**WELWYN HATFIELD BOROUGH COUNCIL
EXECUTIVE DIRECTOR - PLANNING, PUBLIC PROTECTION AND GOVERNANCE**

DELEGATED APPLICATION

Application No: 6/2021/0314/FULL
Location: 22 Church Lane Northaw Potters Bar EN6 4NX
Proposal: Erection of a 5 bedroom detached house
Officer: Ms Emily Stainer

Recommendation: Refused

| Drawing No. | 2019/1327/4 |

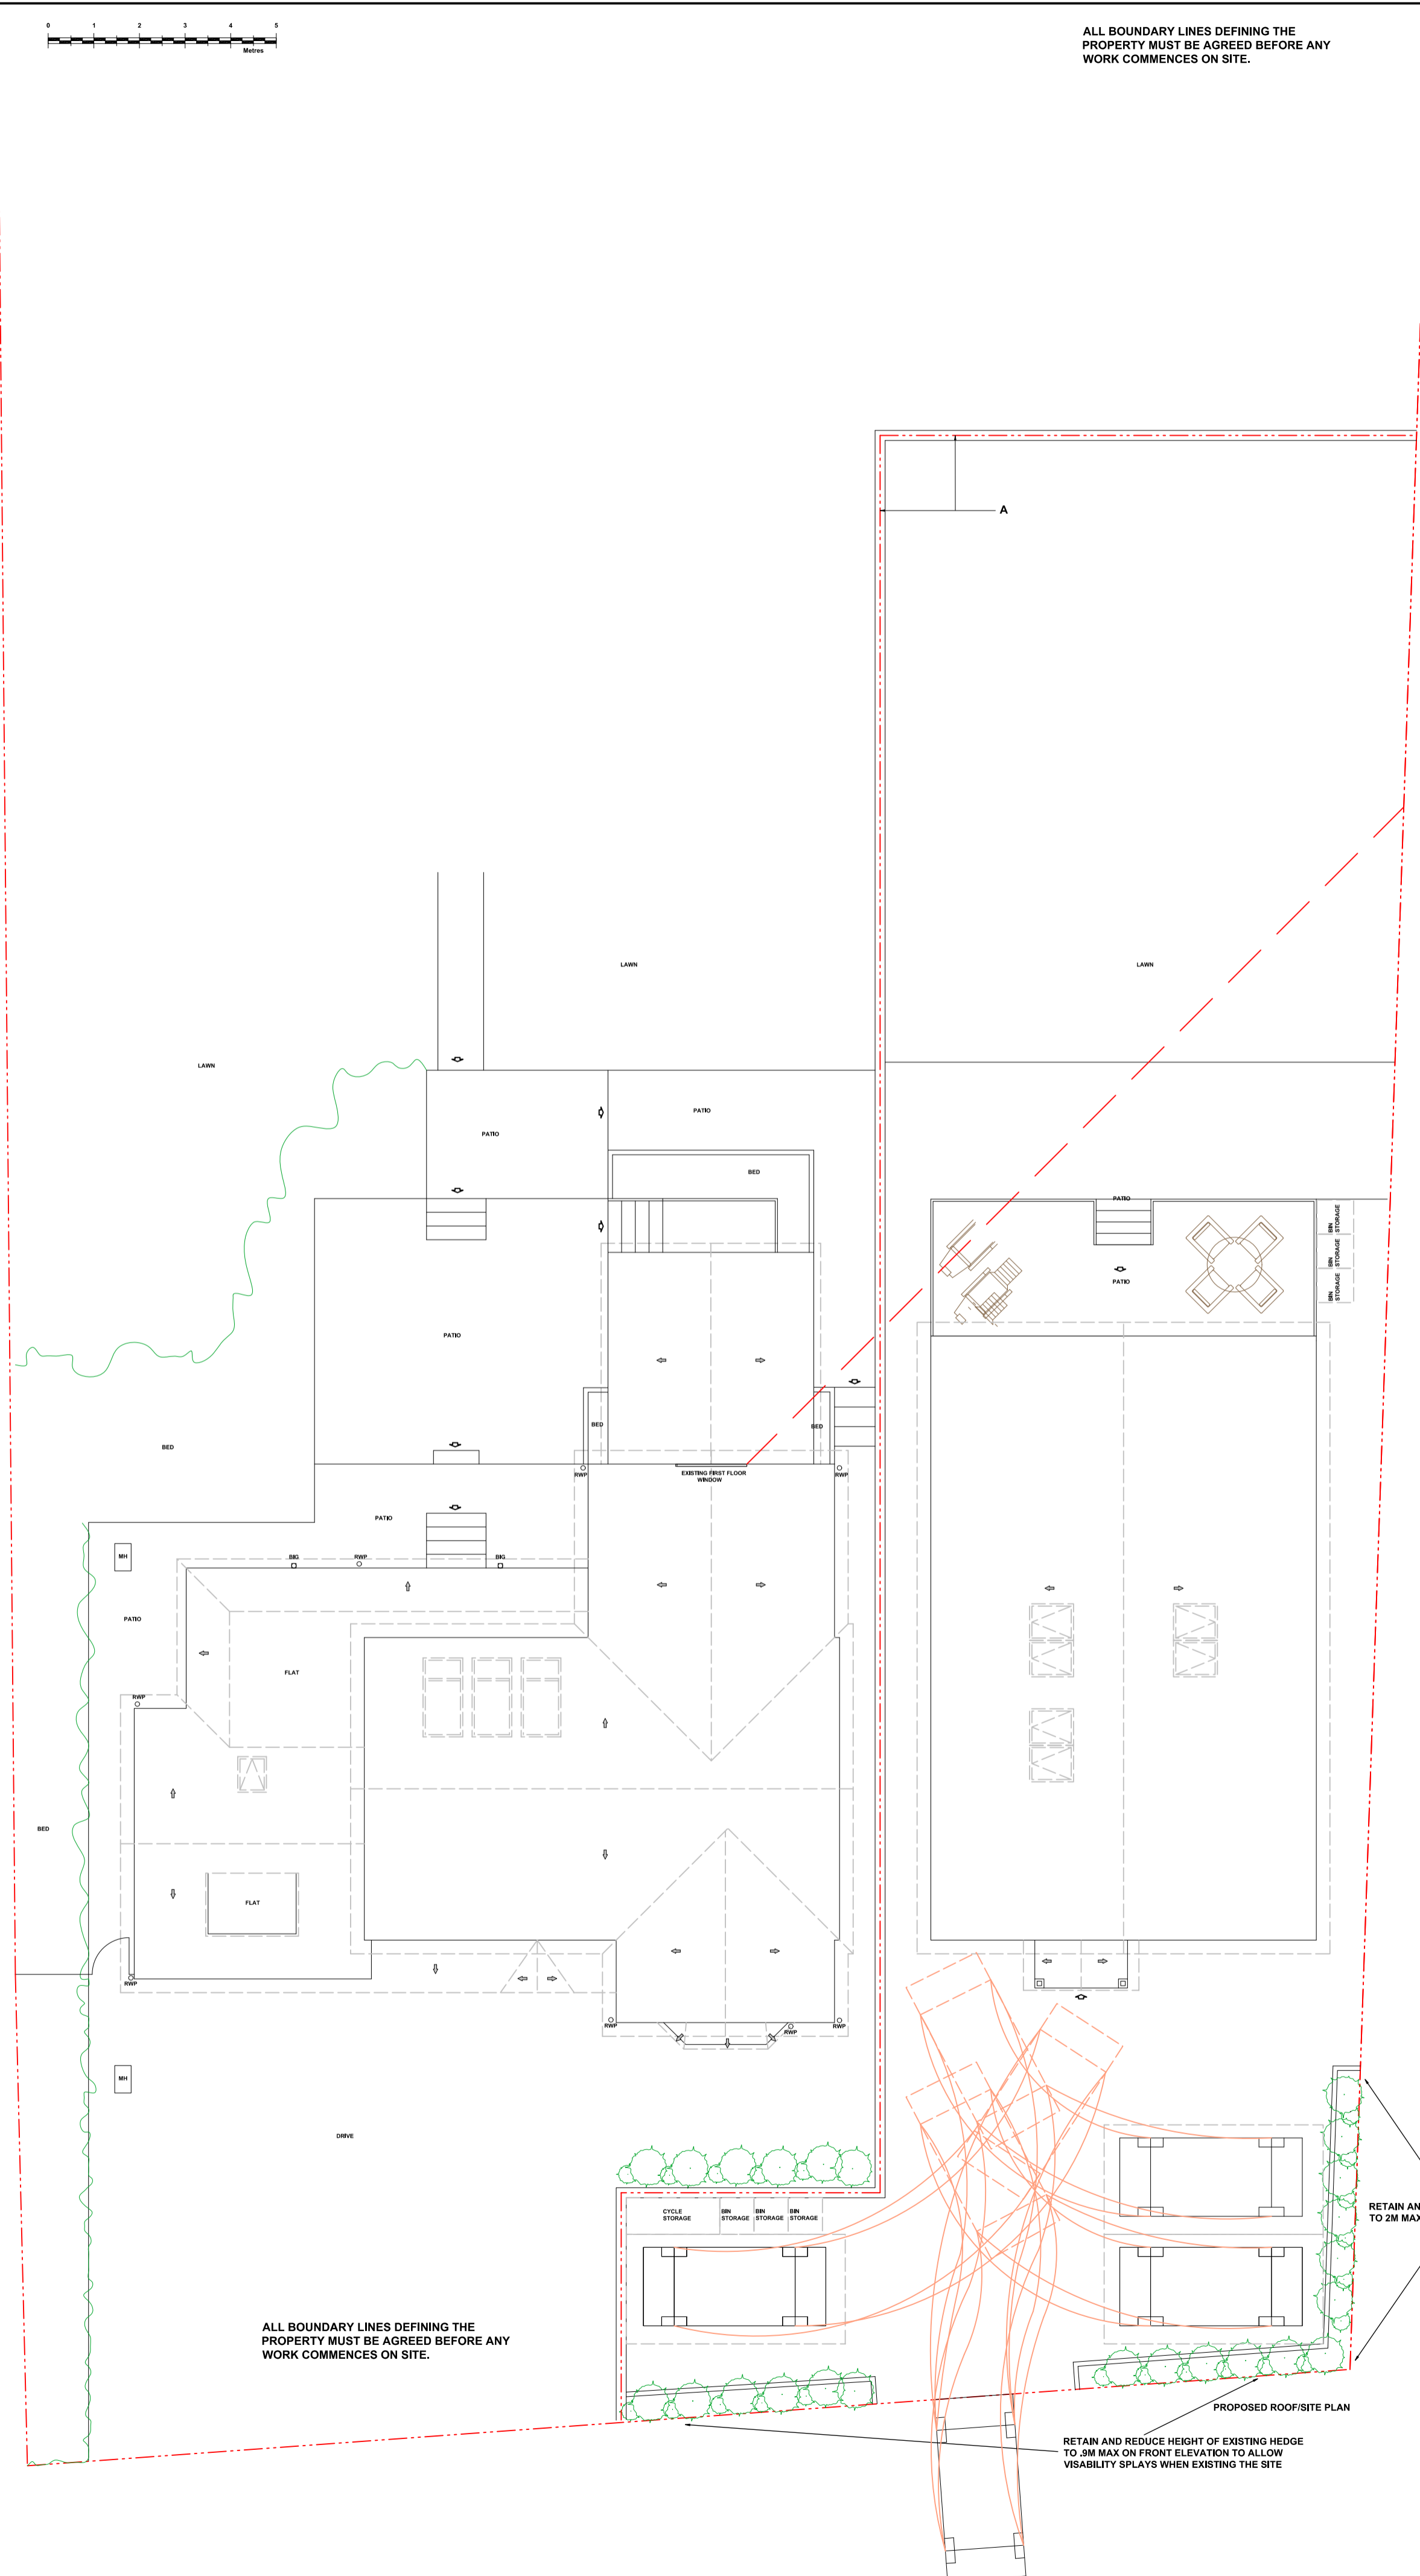
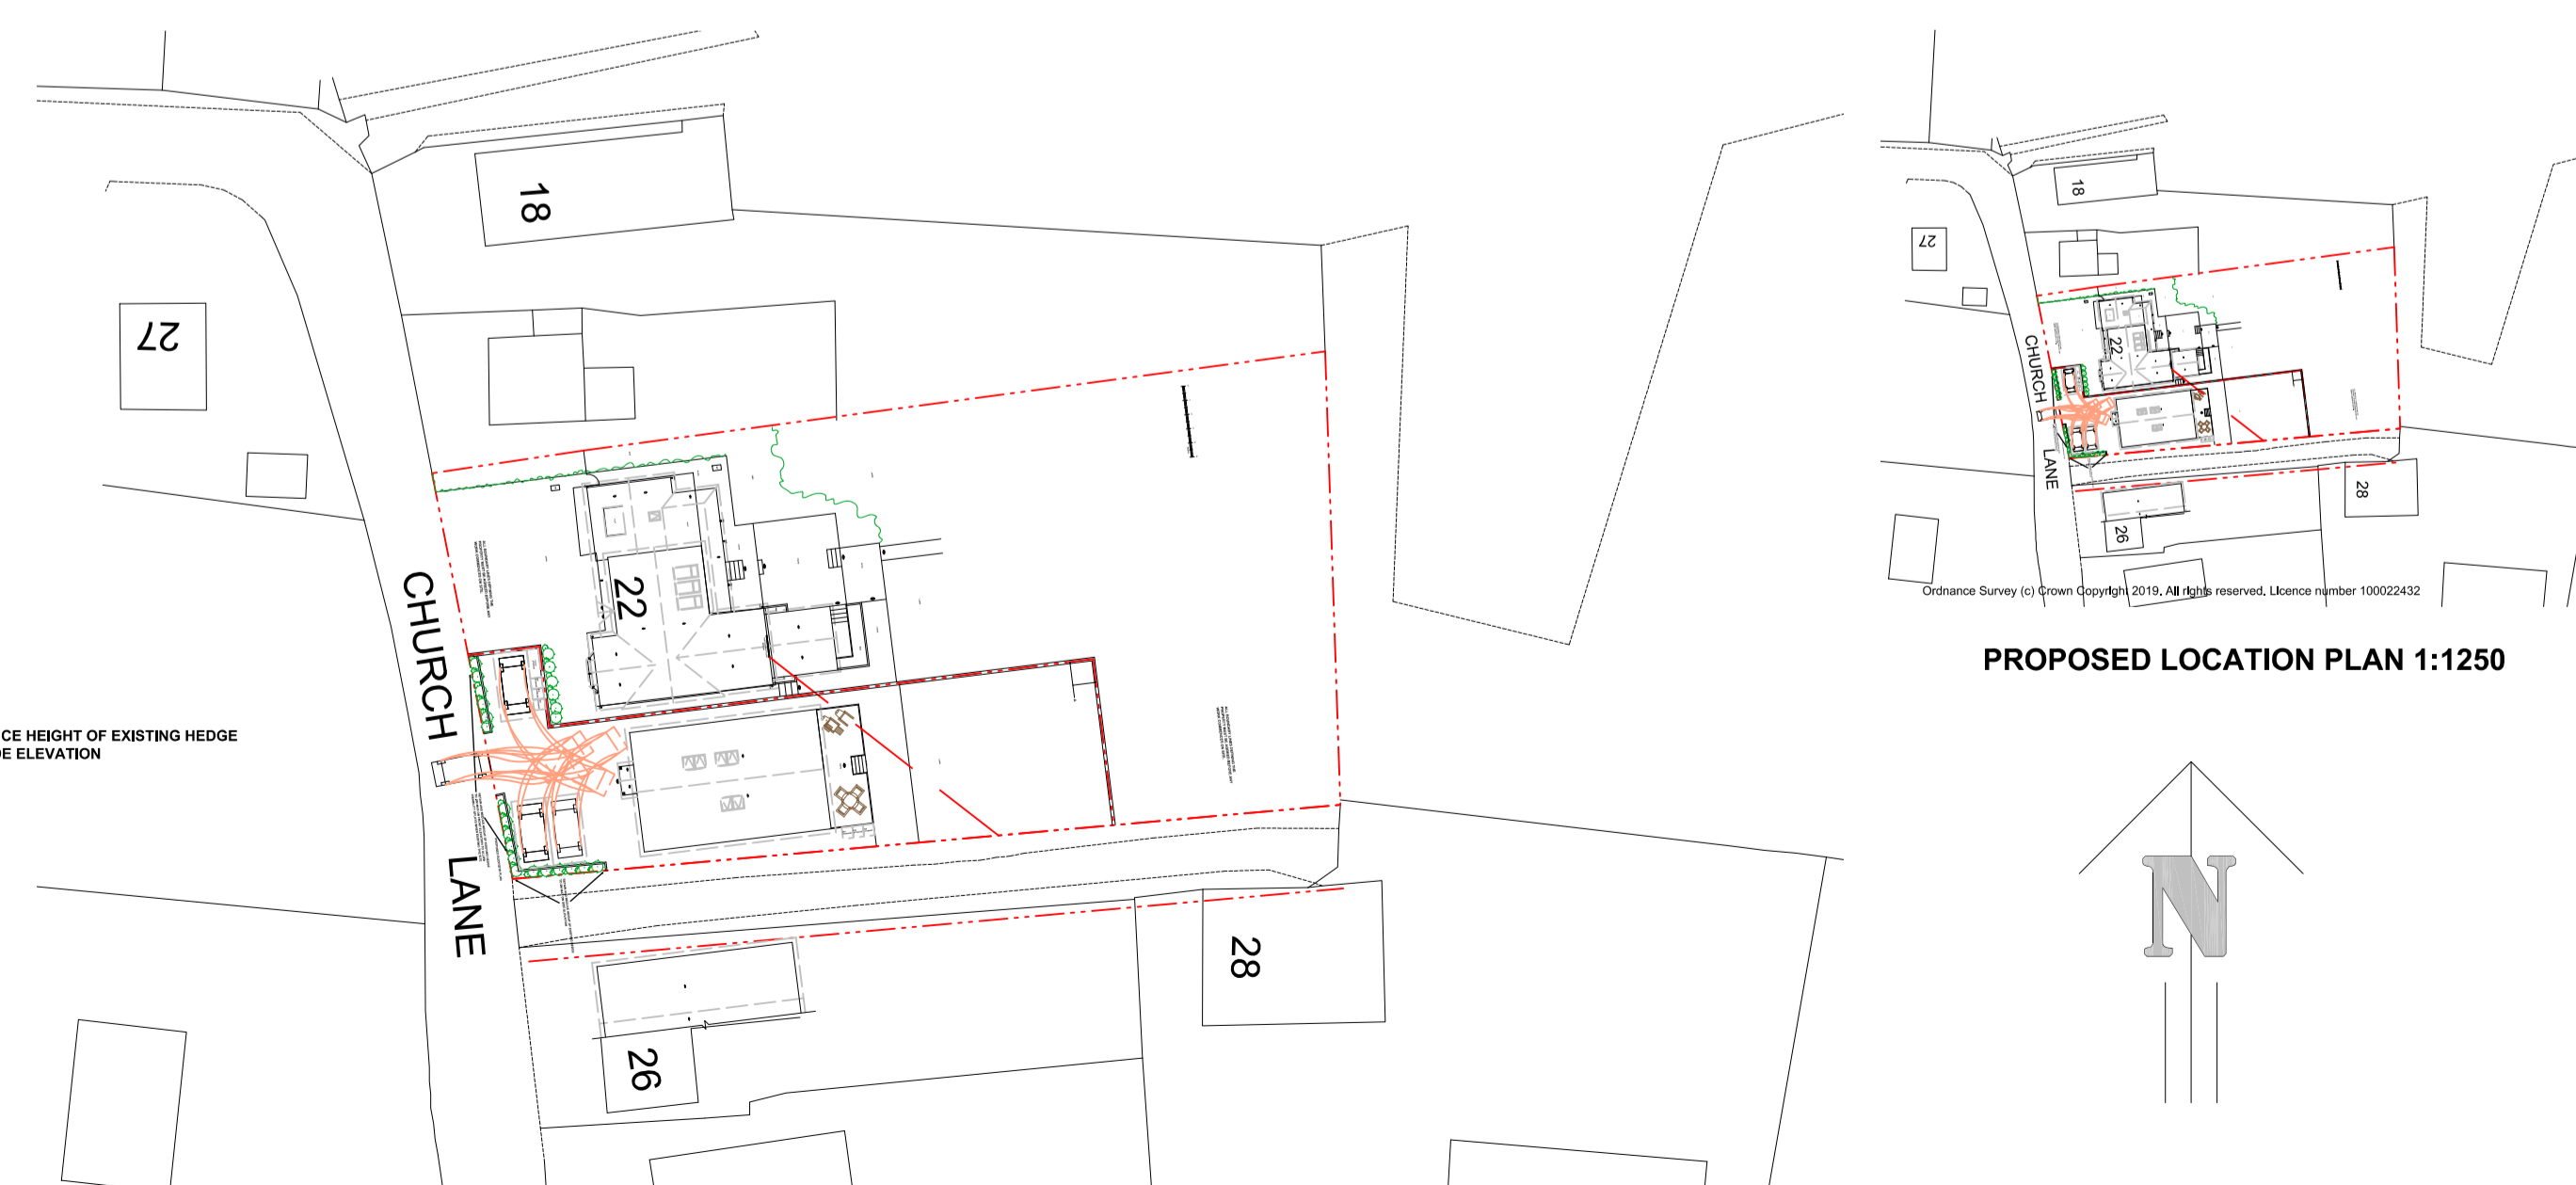
26 Church Lane lies to the south of the proposed dwelling. There is currently a gated access drive to 28 Church Lane which separates the application site and 26 Church Lane. This access is of an appropriate width to mitigate against harm from the built form of the new dwelling. Historic planning records have been consulted and the north facing side windows at 26 Church Lane also appear to be serving the staircases to the property, therefore the dwelling would not have a detrimental impact upon the outlook as these windows do not serve habitable rooms. A rooflight is also present in the roof slope of 26 Church Lane. The historic records for the property indicate that this would not serve a habitable room either, and given the separation distances between the two dwellings the new dwelling would not give way to an unacceptable loss of light to this window. In terms of privacy, side windows at the proposed dwelling can be conditioned to be obscure glazed and fixed below a particular height to prevent overlooking. Similarly, details of boundary treatments can be conditioned to prevent overlooking from the raised patio at the rear of the property as the submitted drawing does not appear to indicate an 'A' indicating the boundary treatment along this boundary.

<p>proposed boundary fence drawings, details of landscaping are limited. Further information would be required in the event of permission being granted to ensure that the materials and planting used within these landscaping features are acceptable. As a consequence, it is considered reasonable and appropriate to impose a condition on any approval requiring that a more landscaping plan be submitted and approved by the Council.</p>
<p>Ecology and Biodiversity</p>	<p>Paragraph 170 of the NPPF states that the planning decisions should contribute to and enhance the natural and local environment by minimising impacts on biodiversity and delivering net gains in bio diversity where possible. Paragraph 175 of the NPPF goes on to listed principles that Local Authorities should apply when determining a planning application. It is stated within Paragraph 175(d) of the NPPF that <i>“opportunities to incorporate biodiversity improvements in and around developments should be encouraged”</i>.</p> <p>District Plan Policy R11 aims to conserve the biodiversity of the borough and seek opportunities for enhancement to ensure no net loss of bio diversity. This is similar to the aims of Policy SADM16 in the Emerging Local Plan.</p> <p>Hertfordshire Ecology were consulted on this proposal and presented no objections given the location and character of the site. However, since shrubs and hedges will need to be removed to accommodate the new building a precautionary informative was suggested to protect nesting birds. In addition, as the planning system should now aim to deliver overall net gains for biodiversity where possible, biodiversity enhancements such as bat/bird/insect boxes are recommended. This can be conditioned as part of a landscaping condition in the event of permission being granted. Subject to the suggested conditions, it is considered that the proposal satisfies the requirements of the District Plan and the NPPF in respect of Ecology.</p>

1. Inadequate information has been submitted to ensure that the proposed development would allow a safe and suitable means of access to the proposed dwelling. It is therefore judged that the proposed development fails to demonstrate that a safe and suitable access to the site can be achieved for all users contrary to Policies D1 and D5 of the Welwyn Hatfield District Plan 2005; Policy SADM2 of the Draft Local Plan Proposed Submission 2016; and the National Planning Policy Framework.
